**Bulga Optimisation Project - Modification 1 (SSD 4960 MOD 1)
Request for Response to Submissions**

The public exhibition of the Statement of Environmental Effects (SEE) for Bulga Modification 1 concluded on Wednesday 27 July. The Department has received nine submissions from government agencies. No public submissions were received.

Figure 2.1 Revised Tailings Emplacement Location

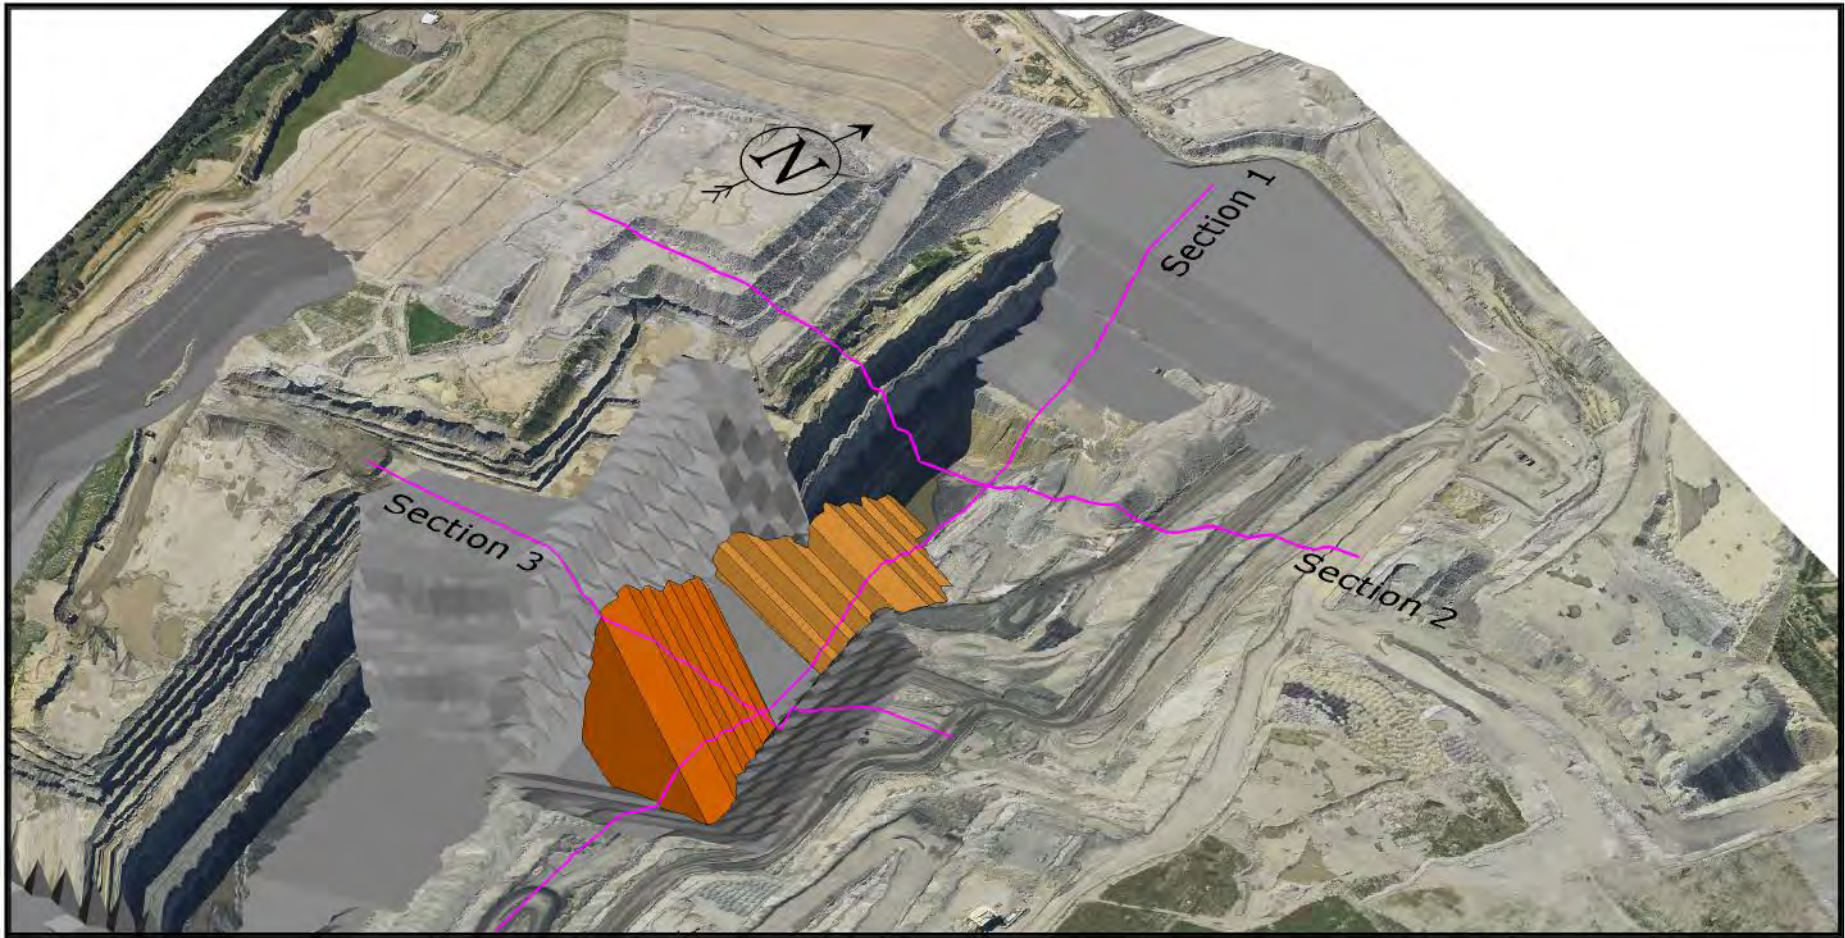
- Glencore is seeking approval to emplace tailings in an in pit storage facility in the Main Pit. The water assessment in the SEE states that the proposed tailings emplacement would not change surface water management requirements and could be managed and operated in accordance with the currently approved Integrated Water Management System (IWMS). However, the Department asks for additional information on potential surface and groundwater impacts, with particular consideration of in-ground migration of water entrained in the tailings.

FIGURE 2.3
Visual Montage Hedly Residence
Final Landform - Eastern Emplacement Area

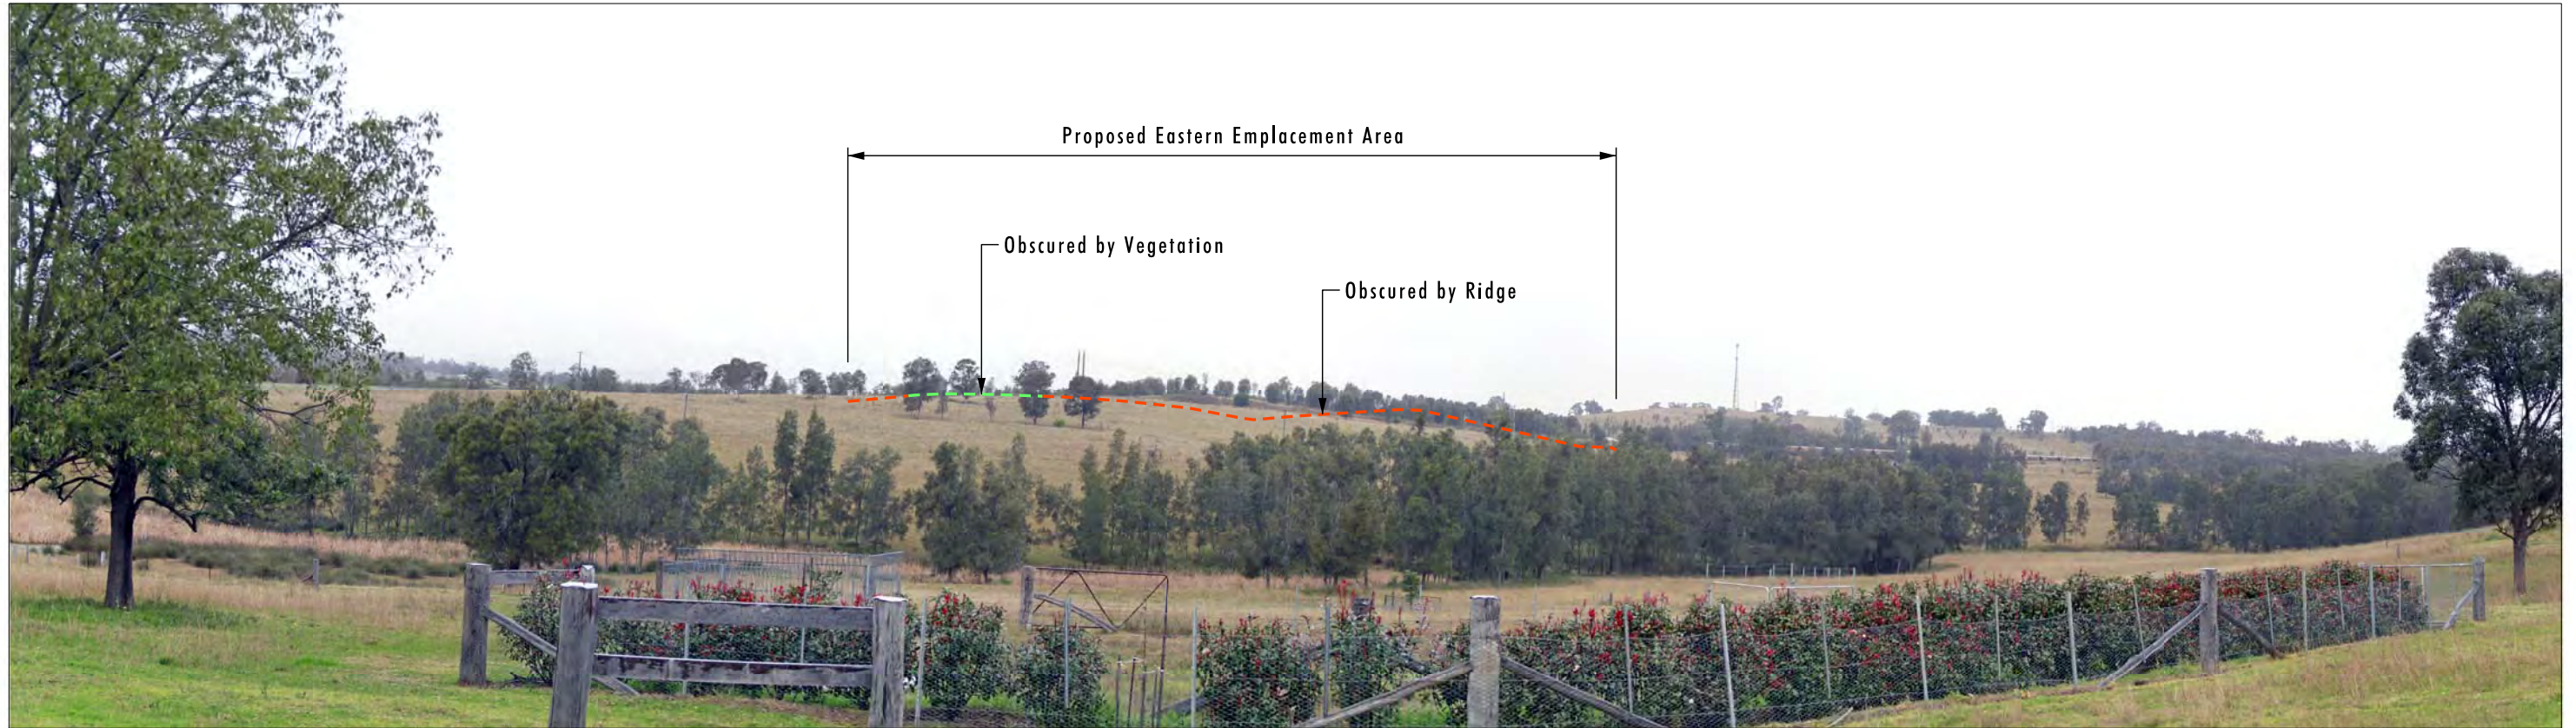
- The visual assessment in the SEE includes a radial analysis from the top of the proposed redesigned Eastern Emplacement Area (EEA). The radial analysis shows that the redesigned EEA would be partially visible from vehicles travelling along Broke Road and from one privately owned residence on Mitchell Line of Road. Glencore has identified that existing roadside vegetation and ridgeline trees would obscure potential views from Mitchell Line of Road. The Department requests that Glencore provide a realistic photographic montage to demonstrate that the potential views of the revised EEA would continue to be shielded by these intervening features.
